Subject: FG/220/18

I am writing this in relation to the late amendment to the plans submitted by the applicants in the planning application FG/220/18 - land at Elm Lodge, Tamarisk Way, Ferring.

Drawing Title **PROPOSED POND ACCESS
PLAN**

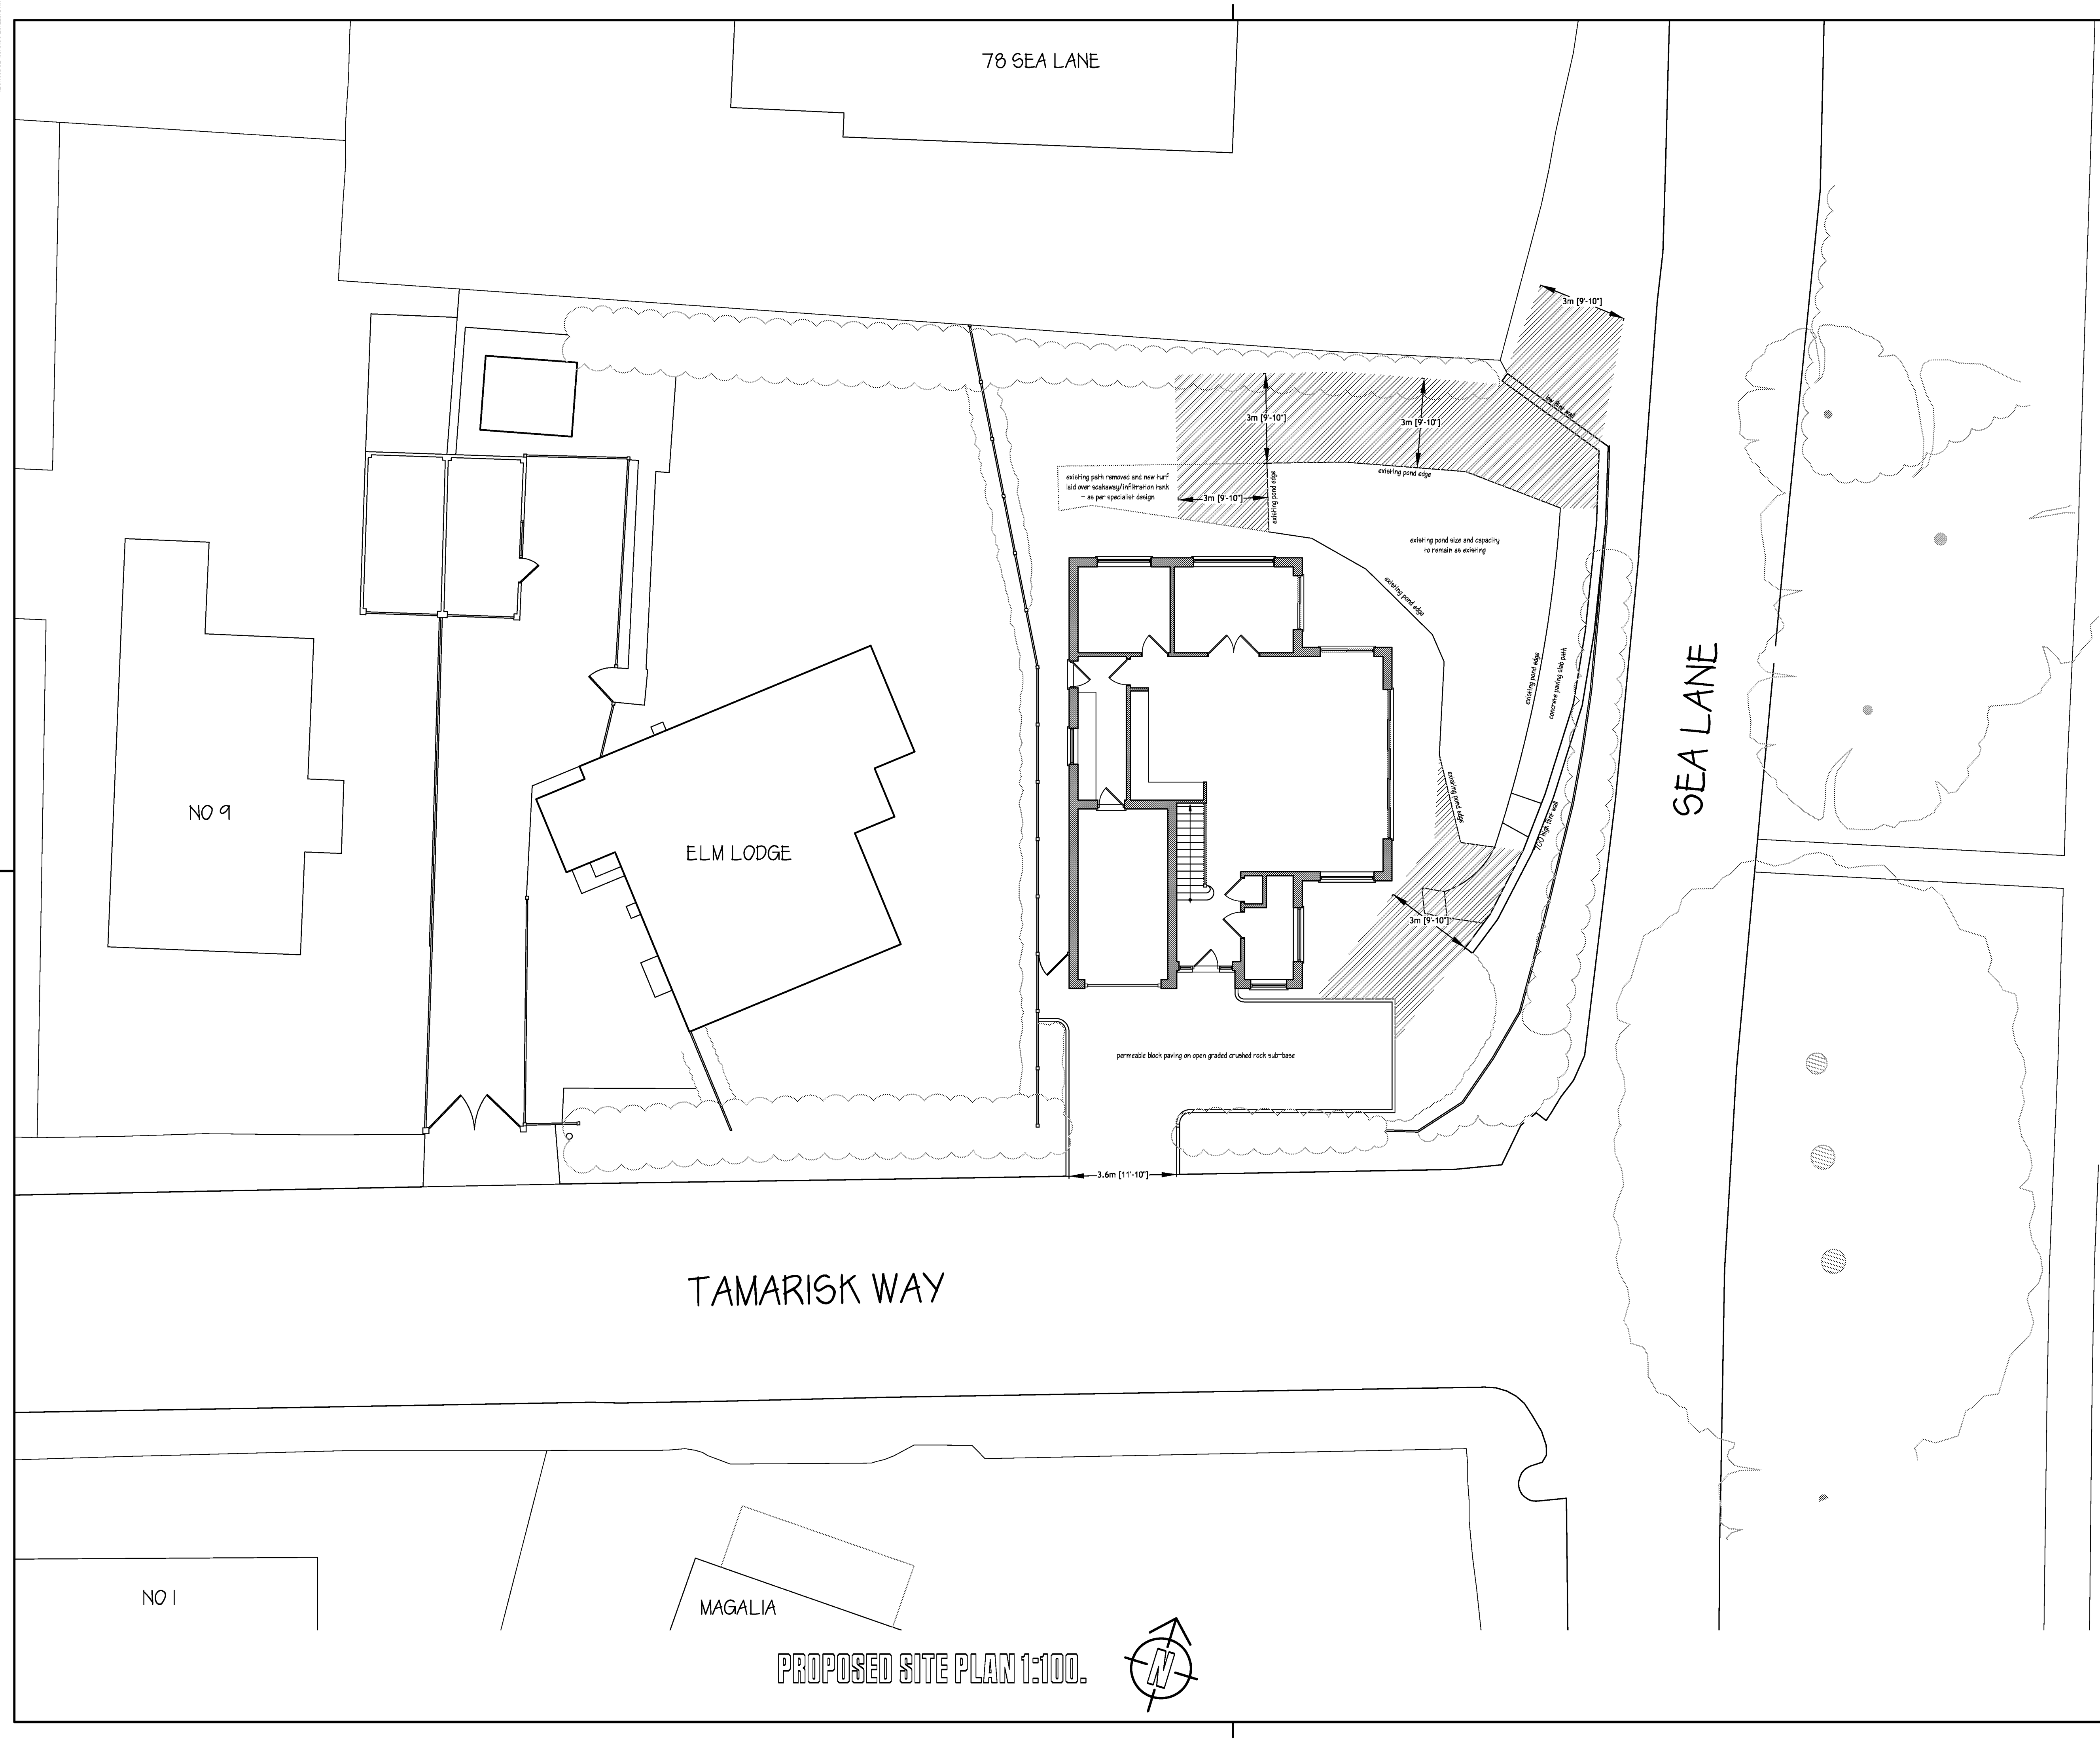
This appears to be an attempt simply to circumvent the very proper and sound objection put forward by the Arun District Council drainage engineers, and the real concerns of the local residents who actually live here and have done in most cases for many years.

There is absolutely no doubt that surface flooding is an issue in this area (evidenced by the photographs submitted by residents) and also there is an issue of a high ground water table here especially after periods of heavy rain (evidenced practically when digging into the soil and also by the number of occasions that BT have to replace cabling in the Sea Lane area after water ingress into their cable system). No amount of fiddling around with the proposed plans on the applicant's computer will and can change this situation. Drainage is our number one concern with these plans and it still appears that the intention is to site a soakaway and its associated cage system exactly in the area of the existing drainage pipe system that leads towards my property. This makes no sense as it is very likely to adversely affect our village drainage system. I do hope that nobody is drawn into a false sense of security this year as we have experienced a very dry winter when water levels are currently much lower than usual. We must expect and be able to deal with future extremes of weather due to climate change.

it must be realised that there is simply insufficient room on this site to shoe horn in another property without compromising the pond and the effective drainage system.

Drawing Title
PROPOSED LOCAL AREA
PLAN

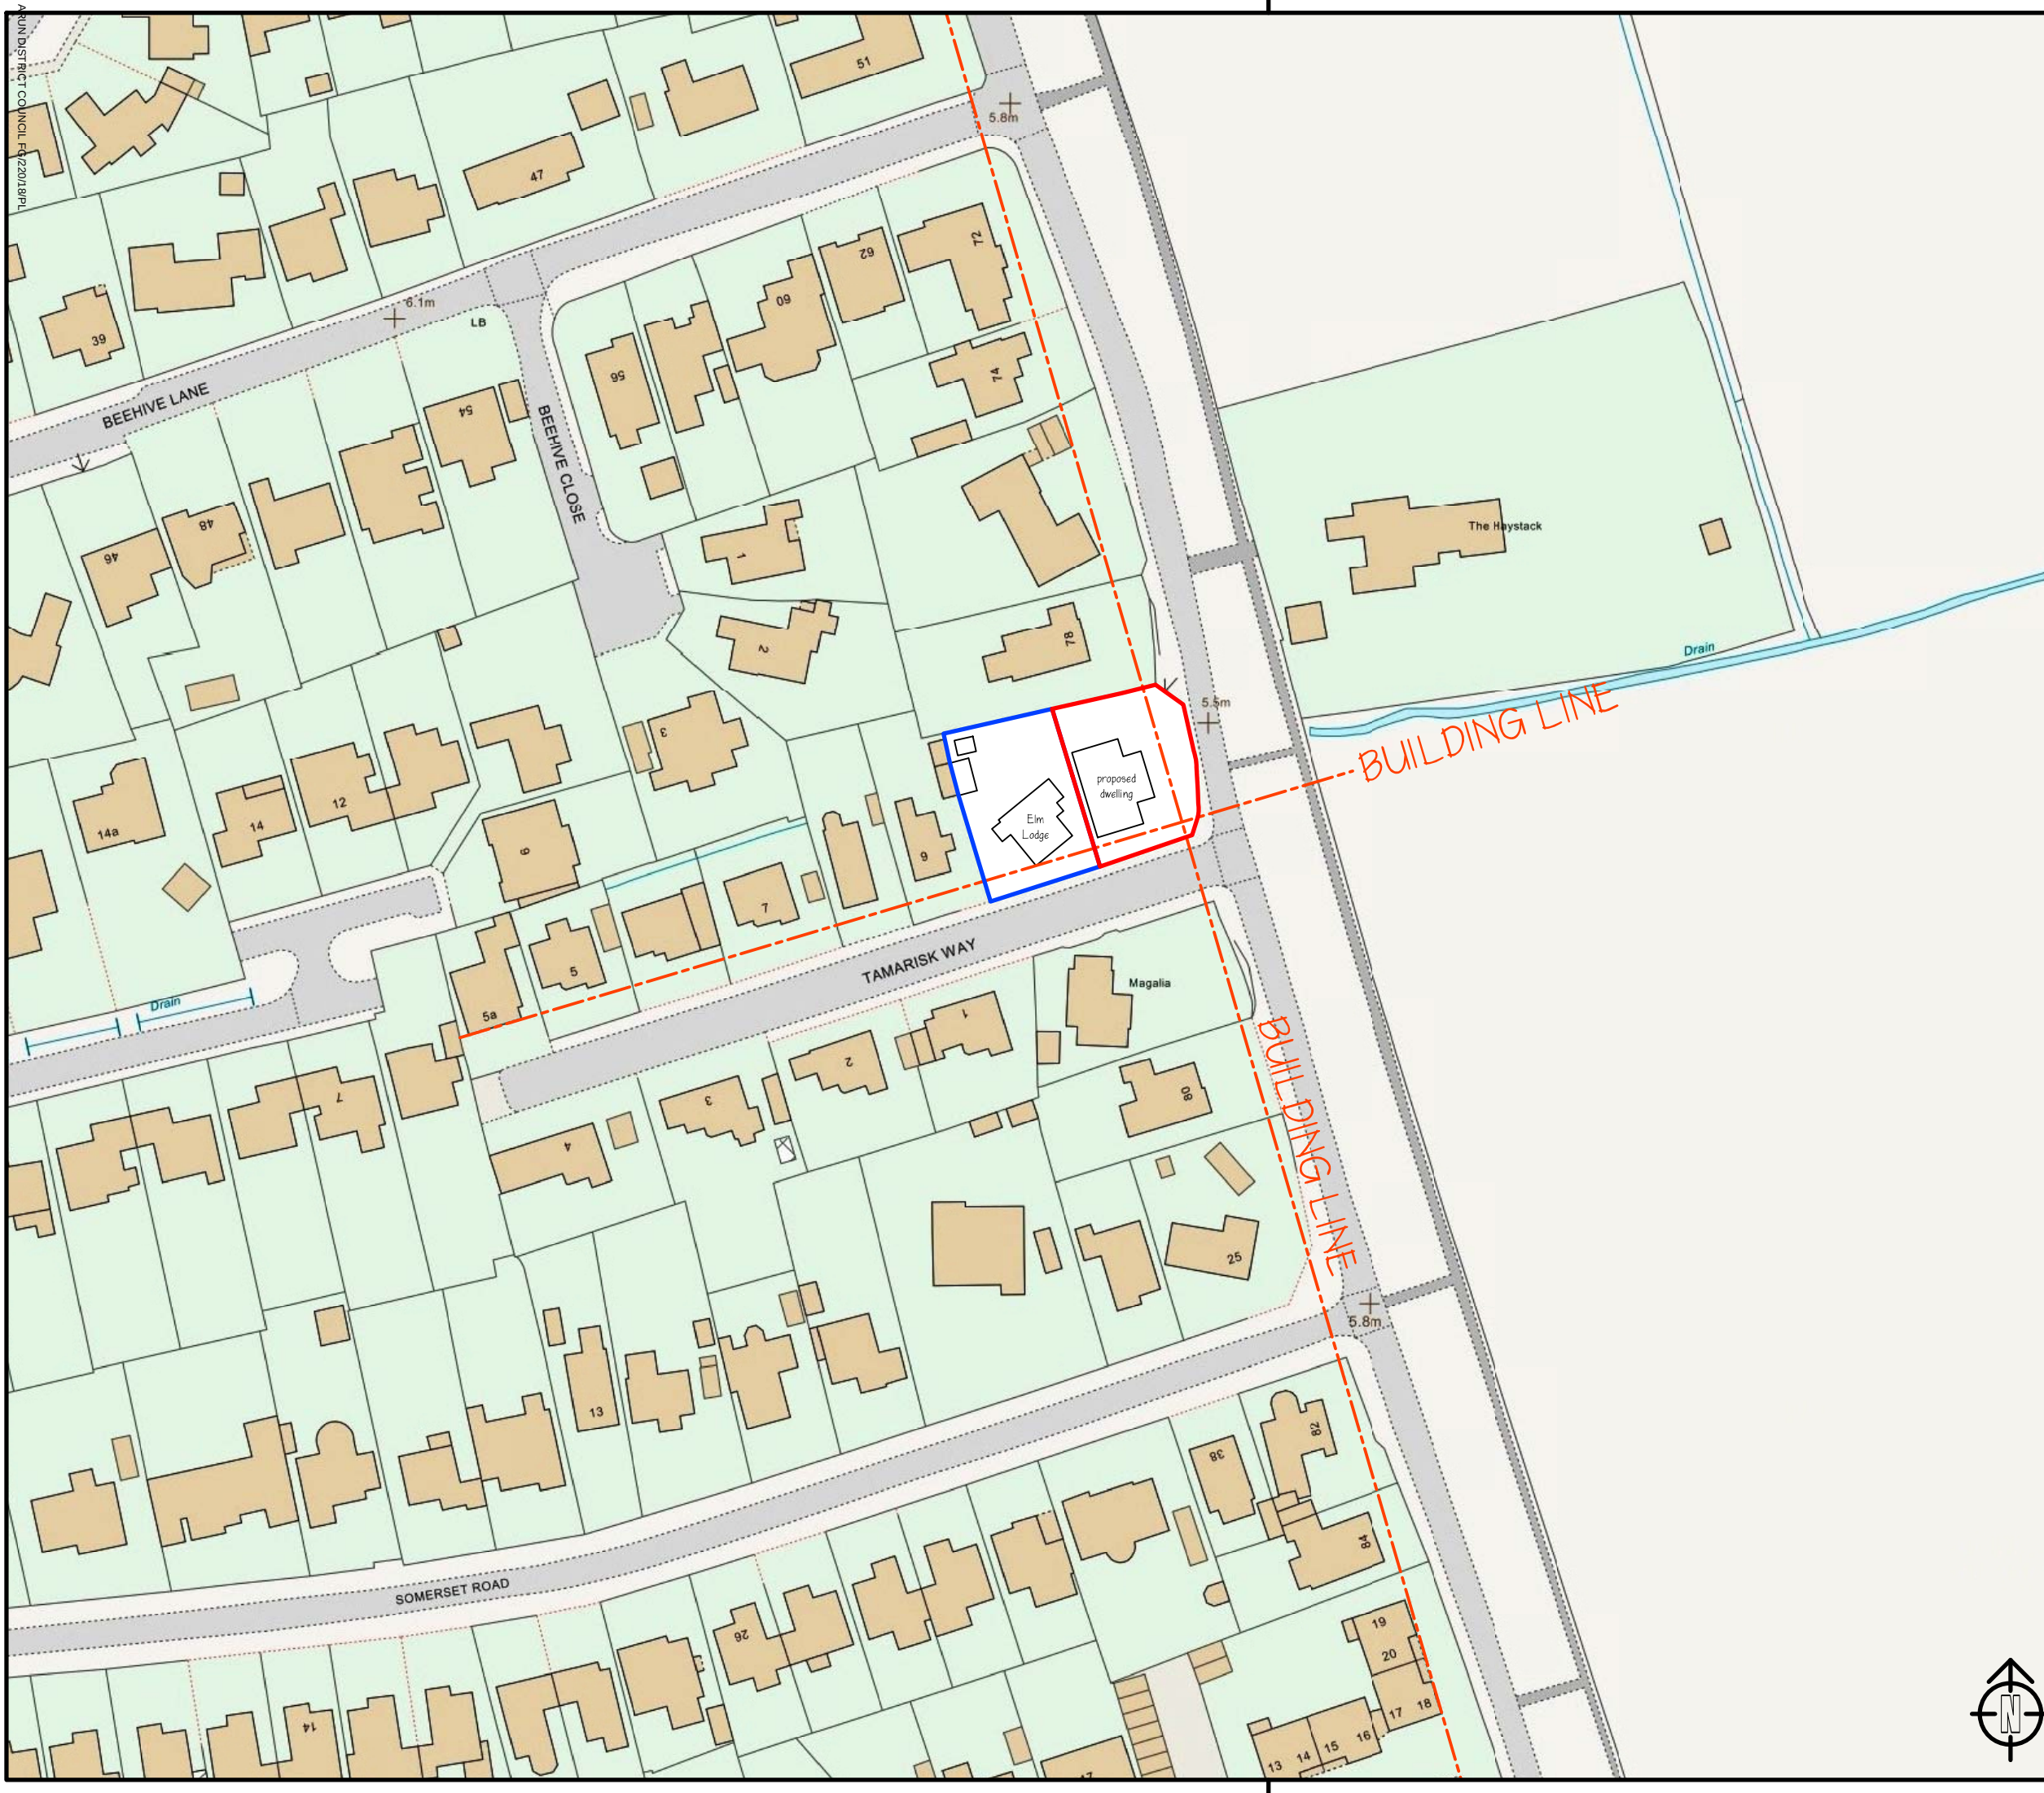
In addition, the updated proposed plan appears to move any new property even closer to the existing Elm Lodge in order to move it away from the pond. The consequence of this would be to make the situation even more cramped and out of character to the local area by squeezing the two properties closer together. Surely
